# CITY OF ALBUQUERQUE

**RE: Entertainment Facility  
3930 Pan-American NE  
Grading and Drainage Plan  
Engineers Stamp Date: 2/1/18  
Hydrology File: G16D145A**

Based on the information provided in your submittal received on 2/2/18, the Grading and Drainage Plan cannot be approved for building permit until the following are addressed:

ENTERTAINMENT FACILITY
3930 PAN AMERICAN FRWY
GRADING PLAN

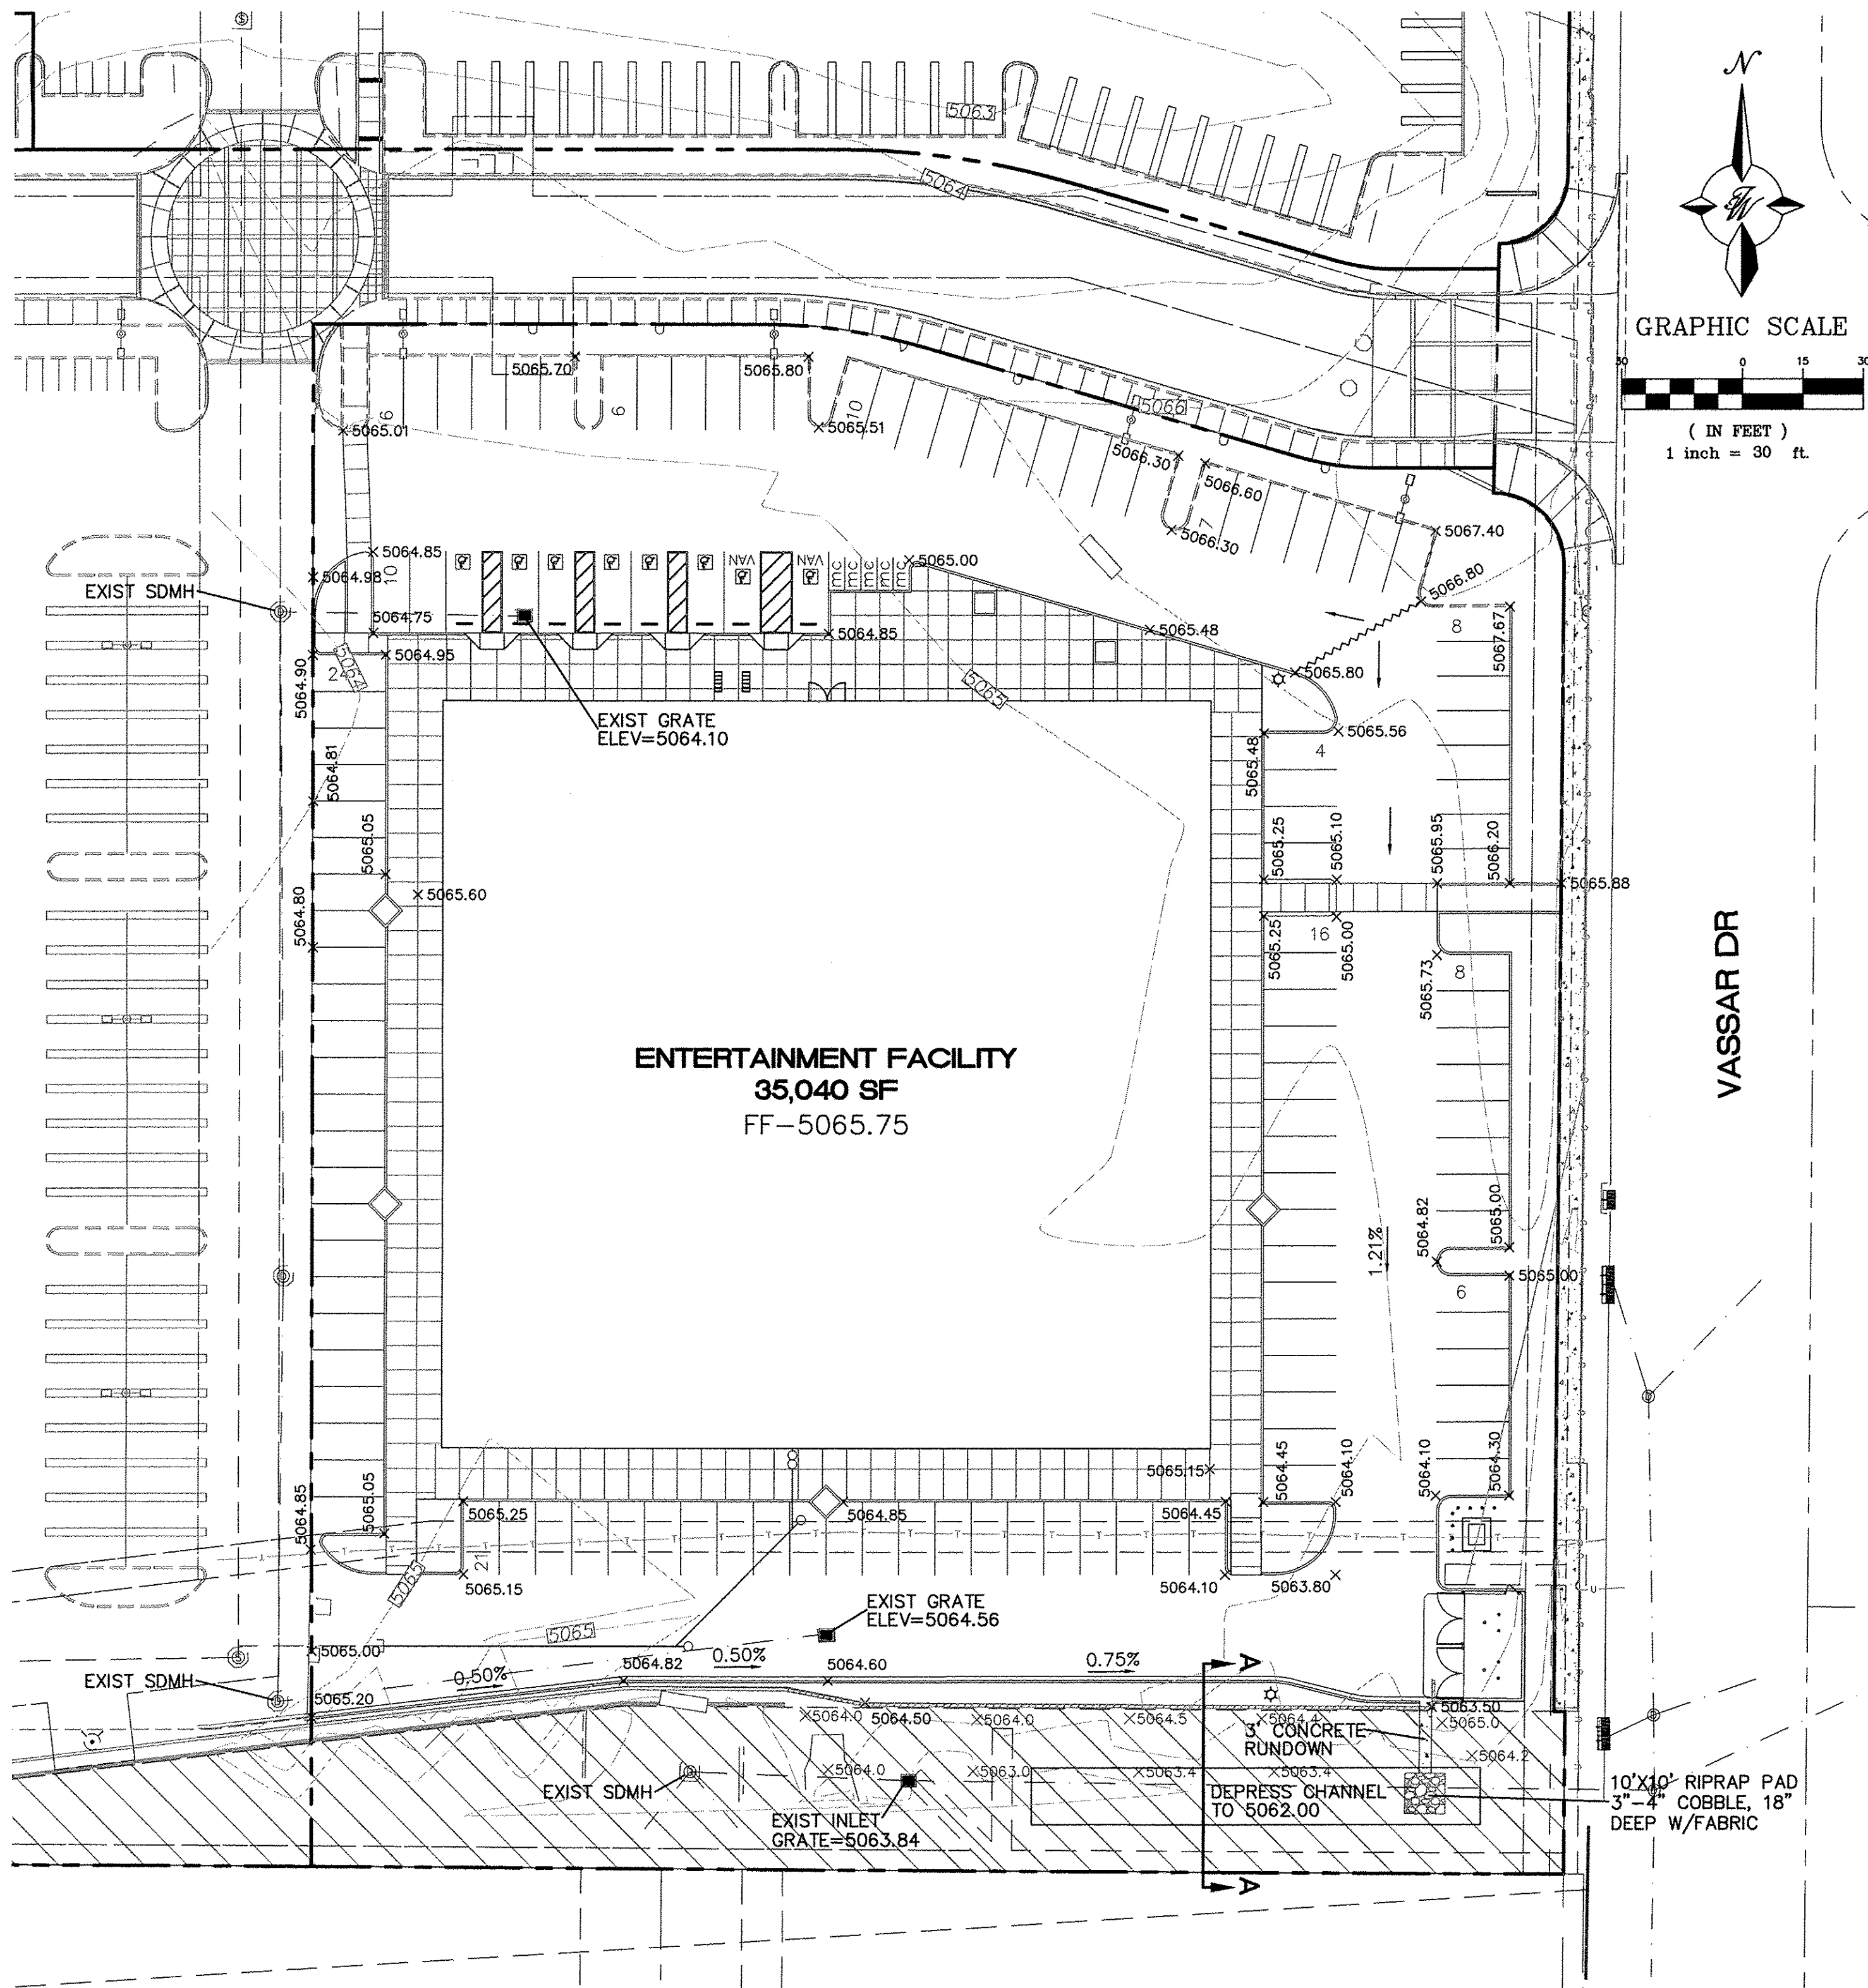
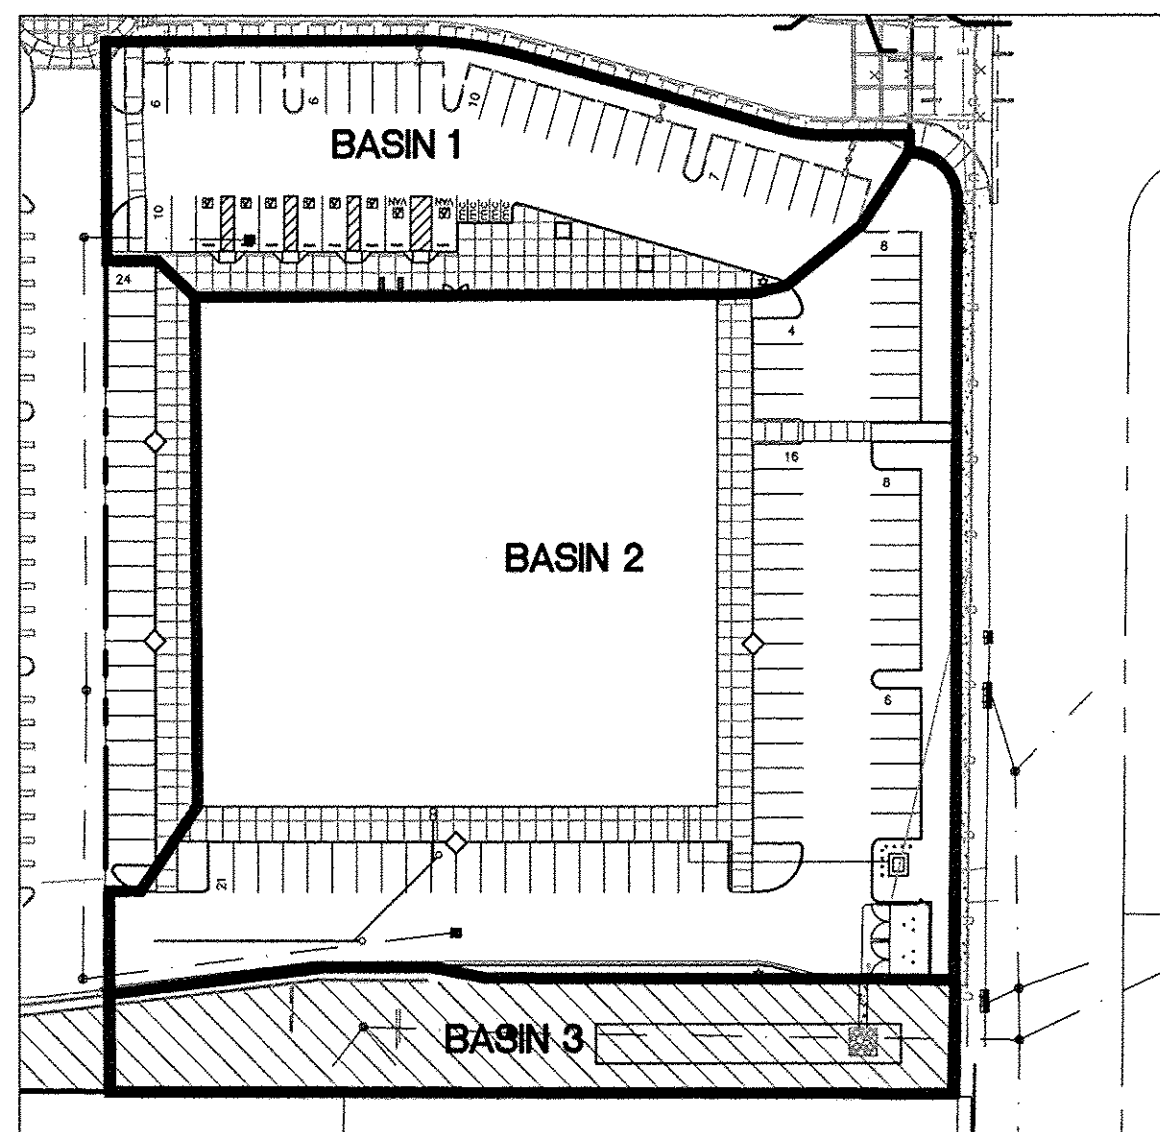
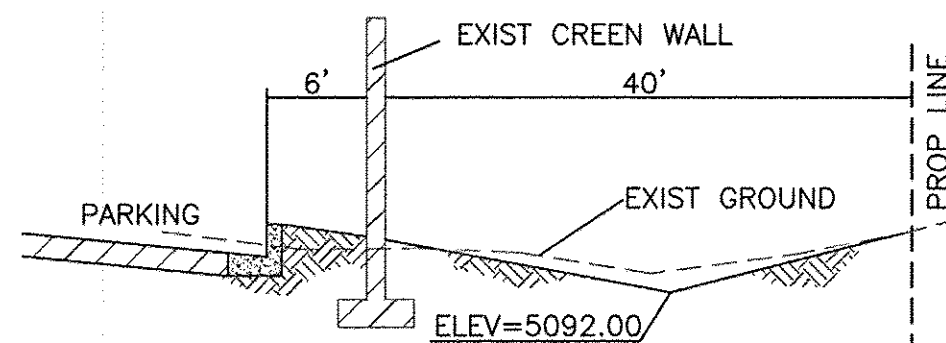
1. The western edge of this project site is not delineated as a subbasin and does not appear to be considered in your drainage plan. Please include.
2. Hatch or otherwise delineate the impervious versus pervious areas on the subbasin map and provide the areas for each. Include a scale for the subbasin map.

3. This site has been previously graded and compacted by human activity; no type B land treatment remains. Please update to reflect land treatment C.
4. Calculate the first flush requirement for each subbasin and show how it will be retained on-site for each subbasin. If unable to retain on-site, the bypass volume needs to be quantified and stated on plans. Payment of Fee-in-Lieu will be required for the bypass volume at a rate of \$8/CF.

5. Basin 2 is described as surface draining south into the drainage channel. However there is an existing inlet in the proposed parking lot that drains to the west. Will this be removed?

6. Who owns the southern drainage easement? Assuming this is a publicly owned easement, the proposal to use it as a first flush facility is unacceptable and an alternate site needs to be selected for first flush ponding. The City will not accept maintenance responsibility for private first flush ponds.
